DESIGN BRIEF

Open Plan Architects Inc. 2305 Hillary Ave. Ottawa, ON K1H 7J2 613-883-5090

p23 November 2022

4 STOREY APARTMENT 1806 SCOTT STREET OTTAWA, ONTARIO

2
A001
GARBAGE ROOM PART PLAN
1:50

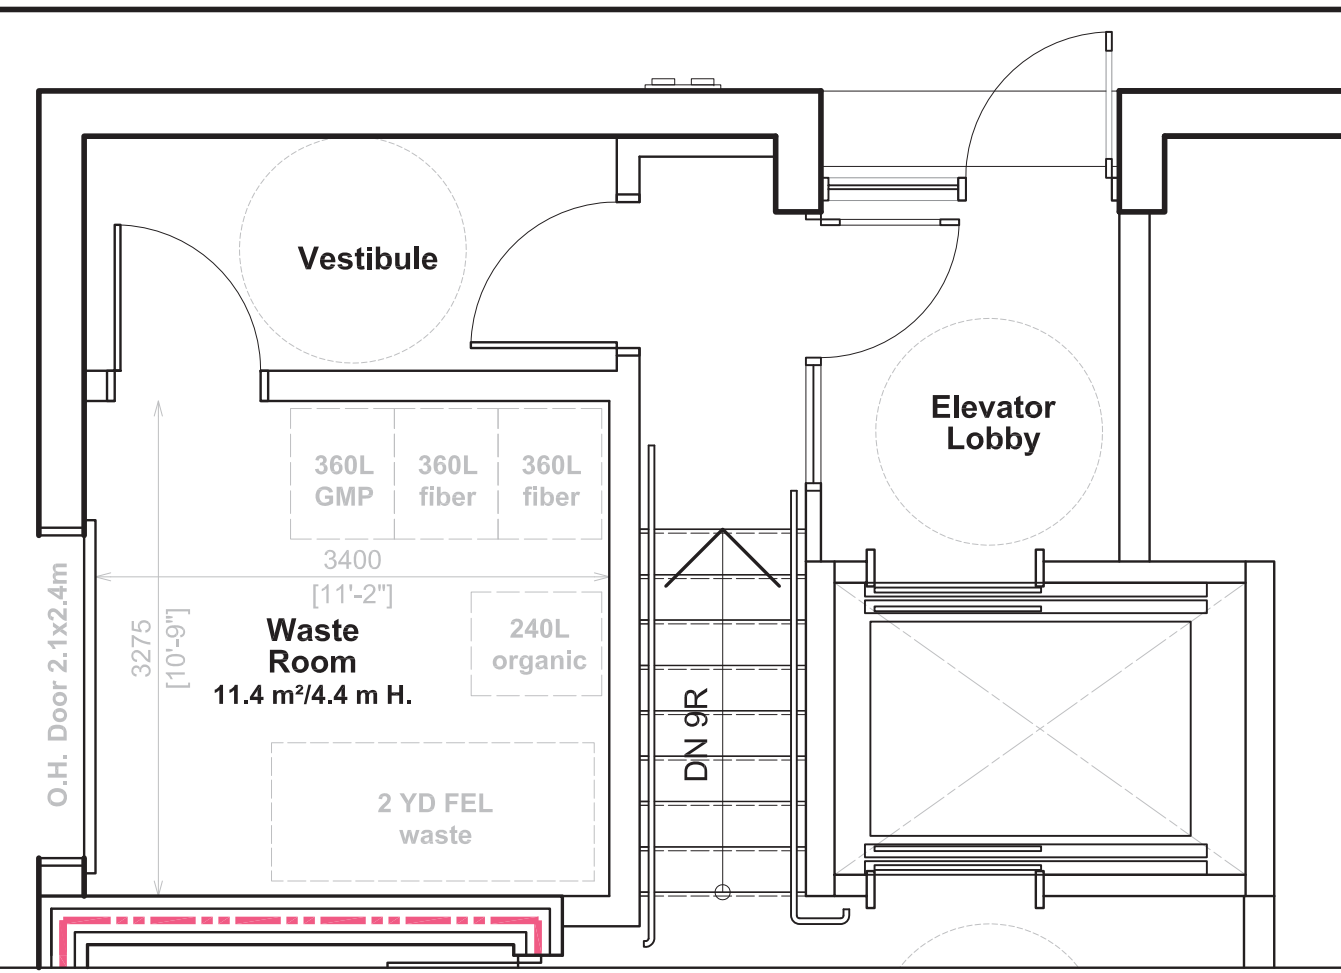
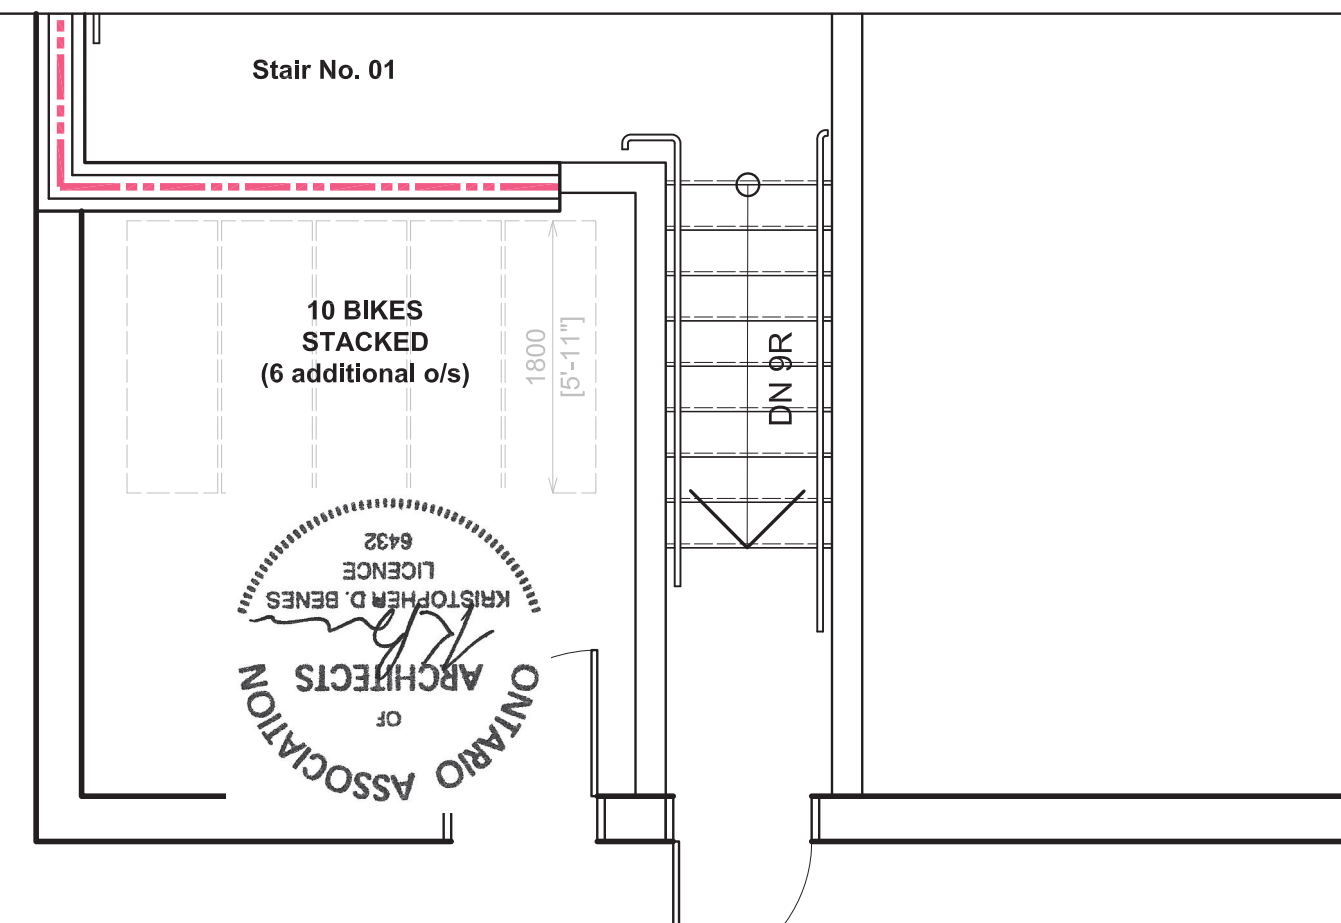
Garbage/bike storage: In a context as sensitive as this we recommend the storage of garbage and bikes be internal to the building envelope;

Response: Waste and bicycle storage rooms have been reintegrated into the interior of the building and are positioned at grade level to make circulation most effective.

1 EAST ELEVATION
A200 1:150

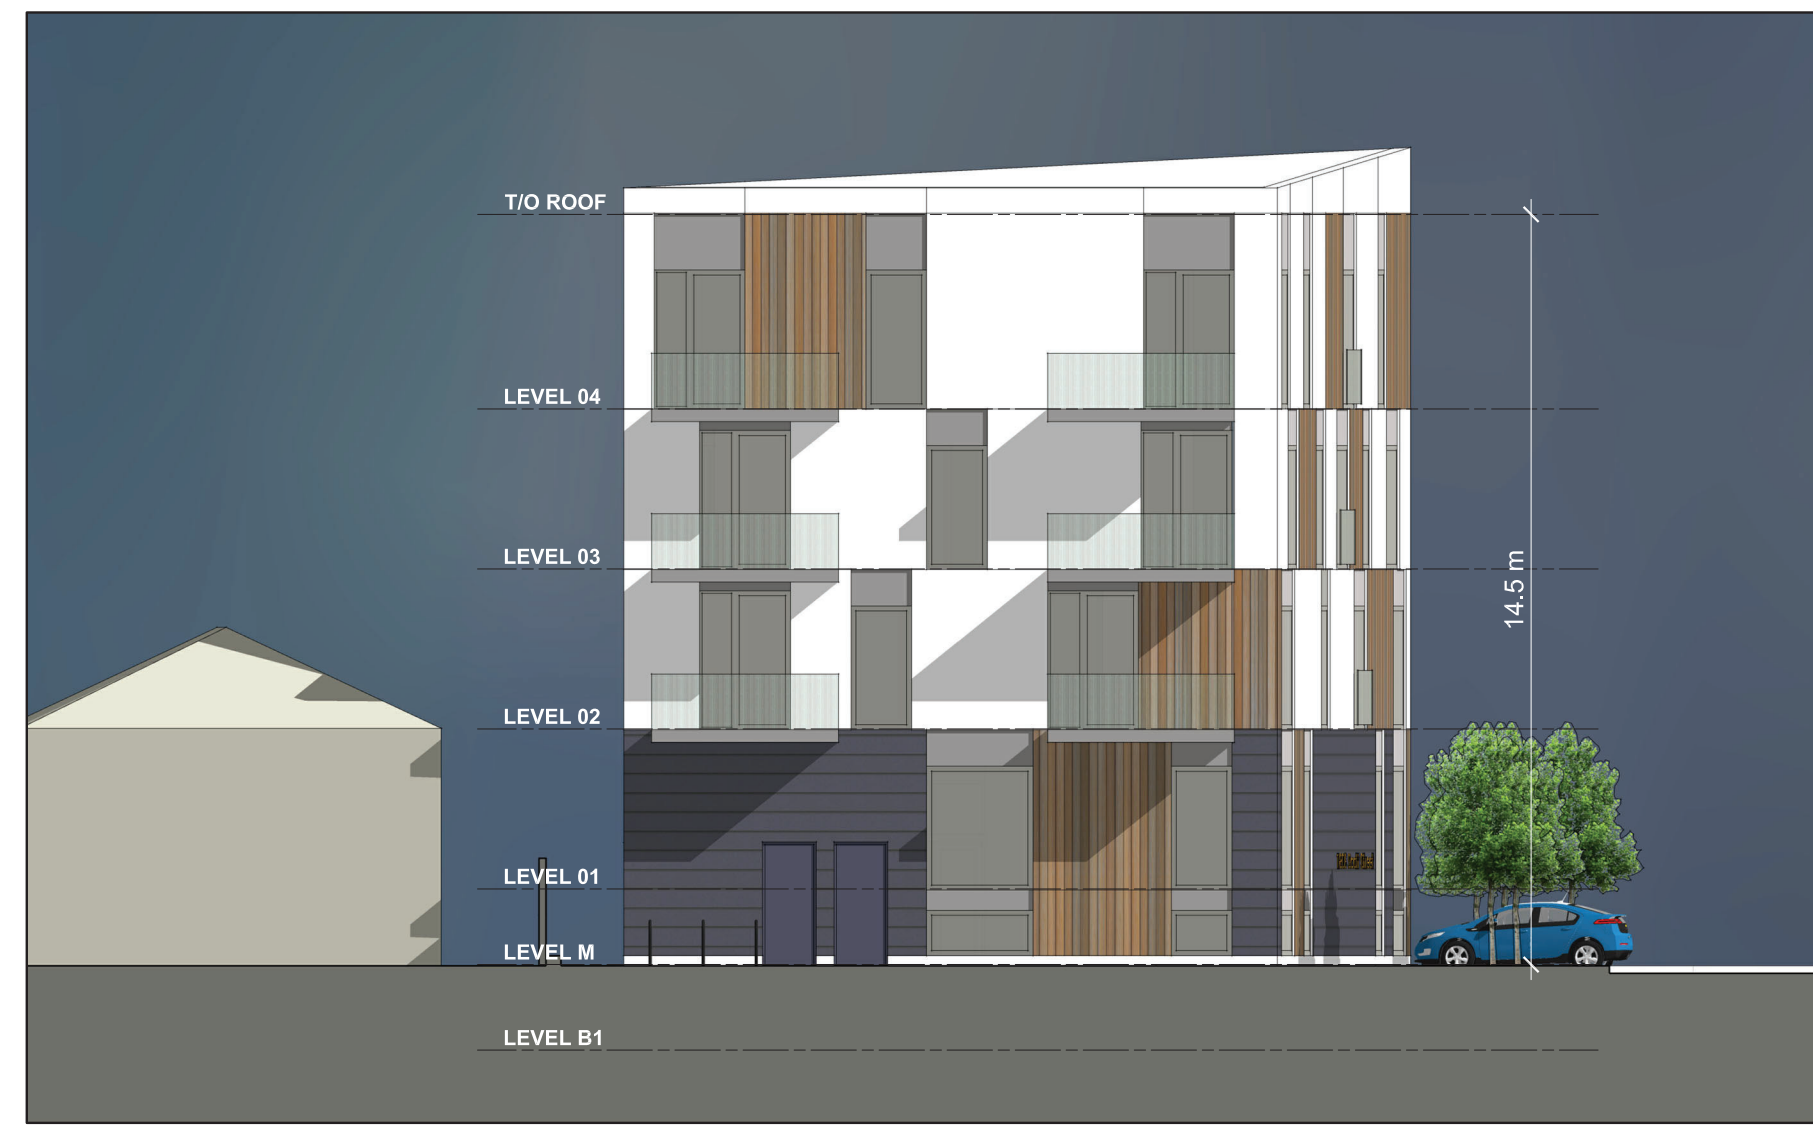
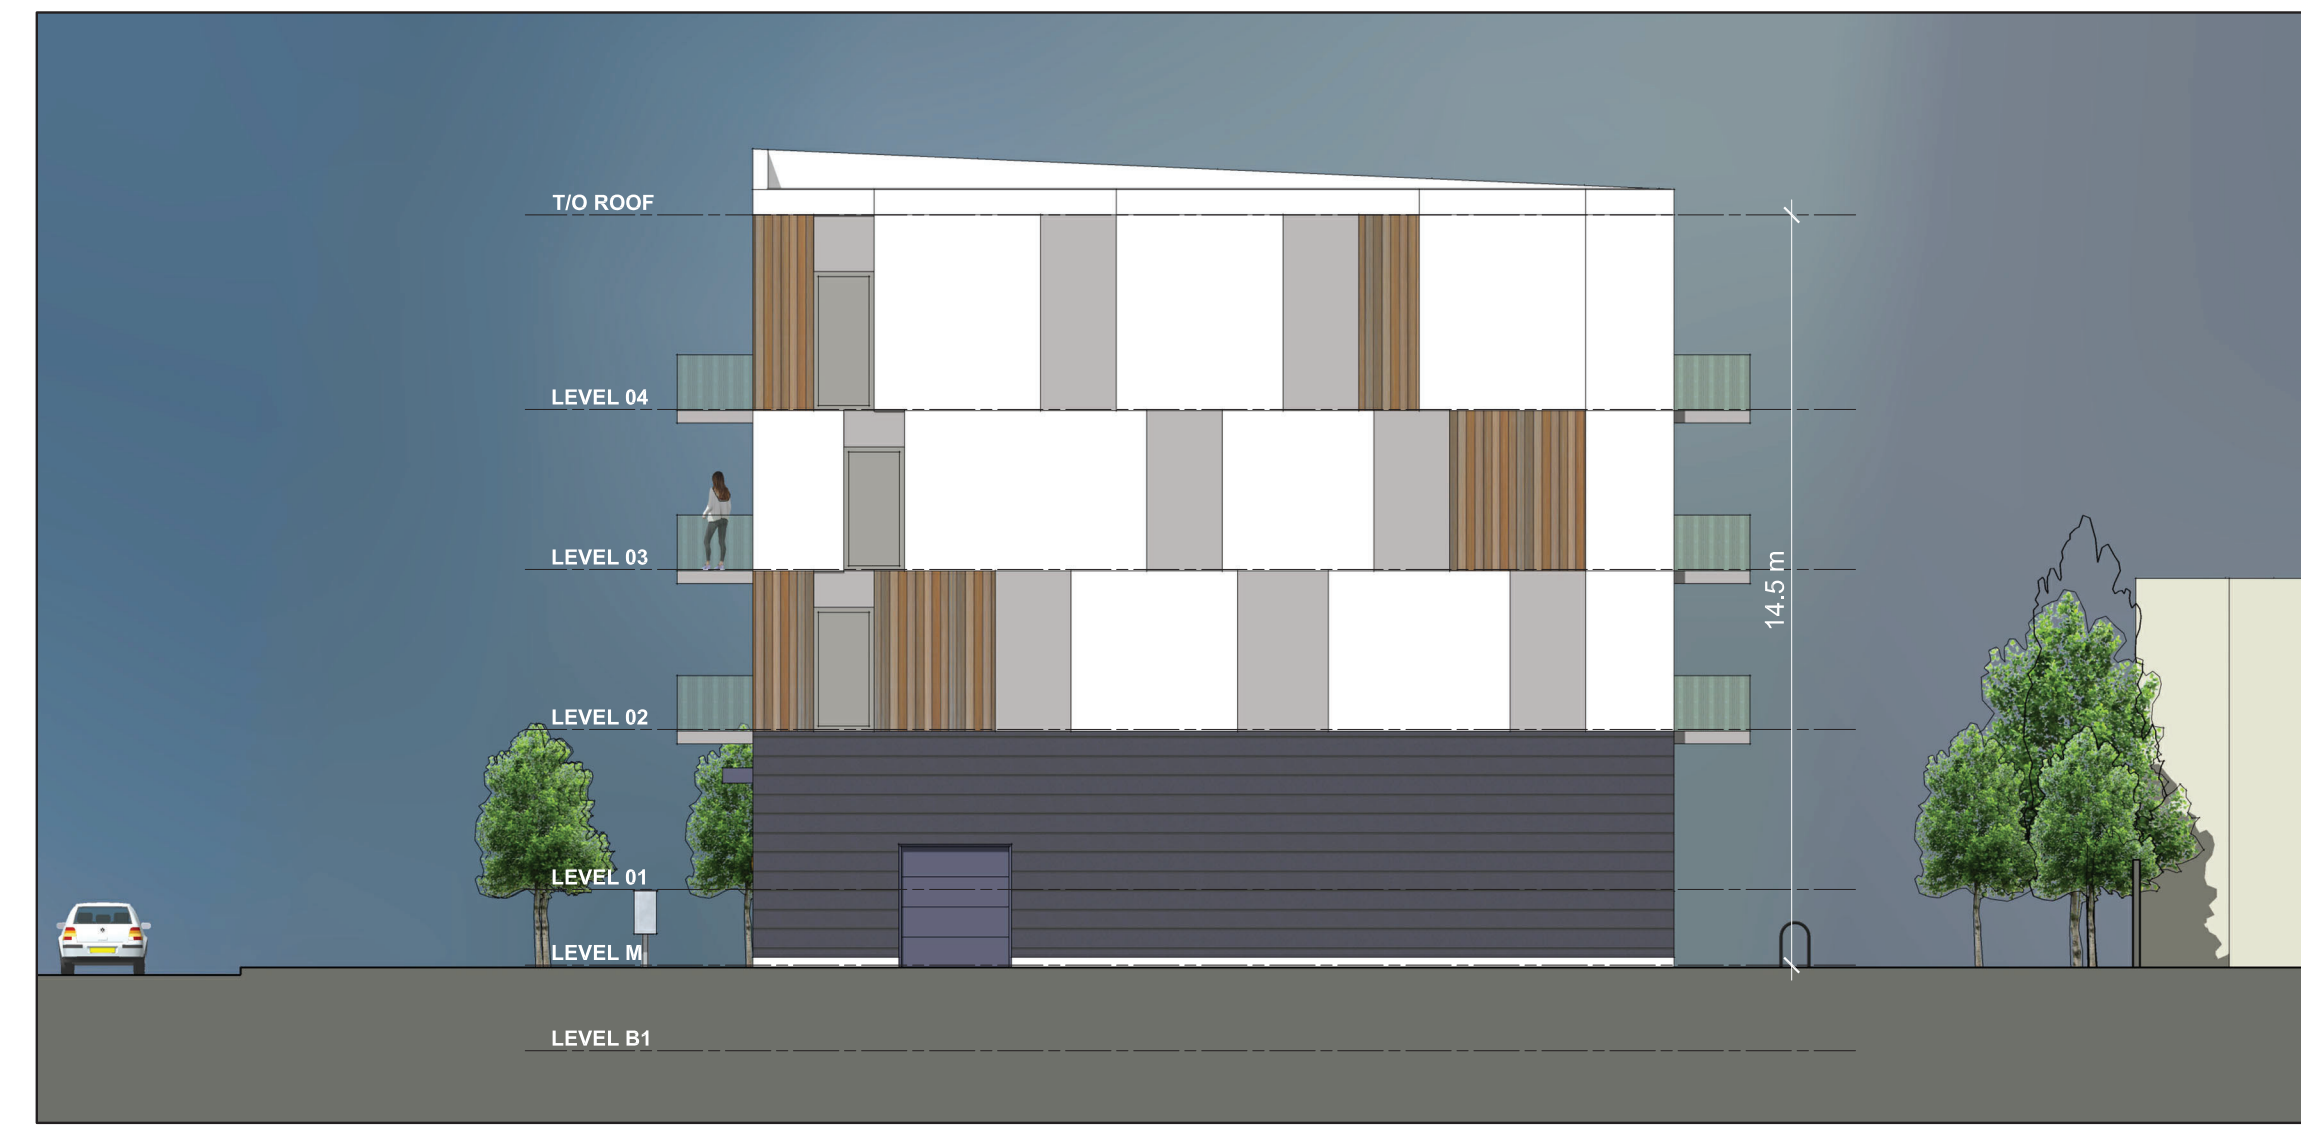
Balconies: Although we appreciate the articulation these provide to the stark massing they should be reasonably designed to mitigate over-look on neighbouring properties and not negatively impinge on the street facing facade. Perhaps the columns could be removed?

General massing: We appreciate the creative use of material to help break down the form, however, we believe further articulation to soften the box expression may benefit the design such as providing stepping on the facade and/or setting back portions of the upper floors to help the jump in scale fit into the context;

Response: The balconies, which were previously facing west, have been reoriented to the south. The balcony columns have been removed in favour of cantilevered balconies as recommended.

Response: The fourth level and balconies have been stepped back by 0.4 m. Together with the parapet, which slopes downward towards the lower lying buildings south of the site,p these measures will assist with the desired visual transition.

**LANDSCAPE PLAN**

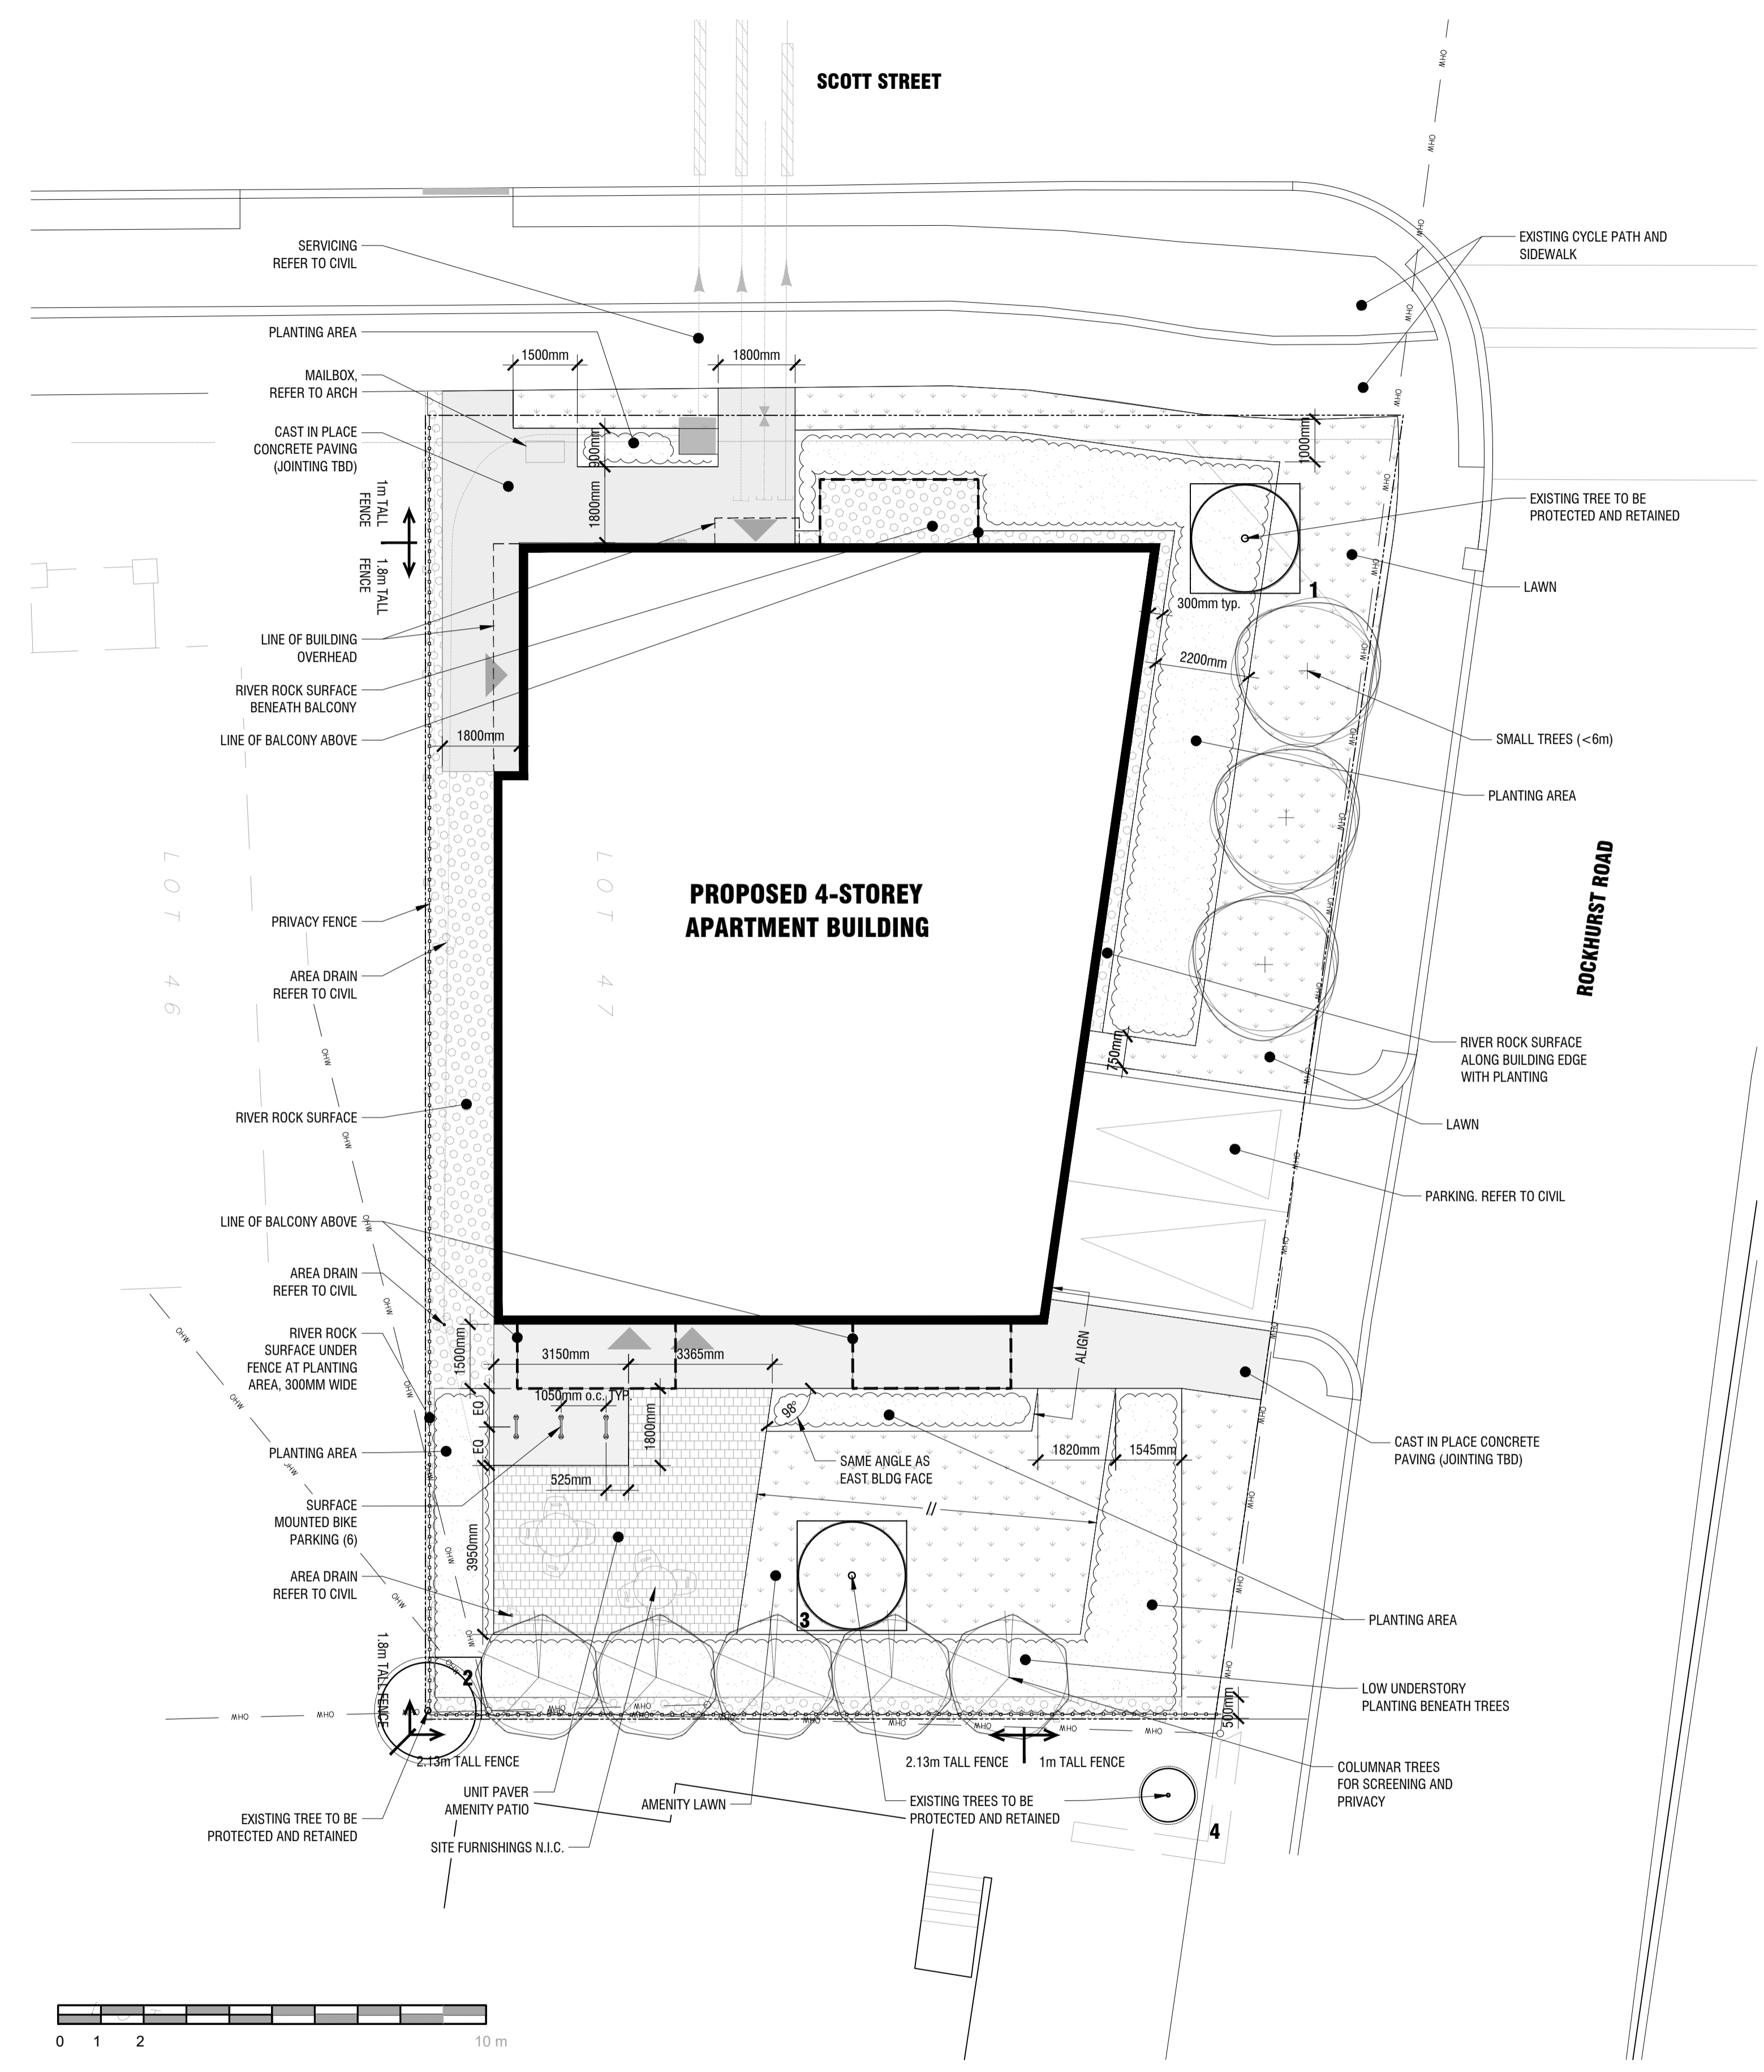
Rear yard amenity/landscaping: We recommend this area be clearly defined for how it will be used and visually protected from the street;

Trees: We recommend efforts be made to preserve existing trees and for the Site Plan to indicate these and provide locations for new trees on the site.

Response: Fencing will define the amenity area with respect to the neighbouring sites, and to soften the transition to the road and parking spaces, landscaping beds have been added.

Response: 3 existing trees will be preserved (please refer to landscape plan) and the proposal includes a plan to add 7 additional trees. These will be located along Scott Street (3 new trees), at Rockhurst (3 small deciduous trees) and in the interior side yard (1 small deciduous tree).
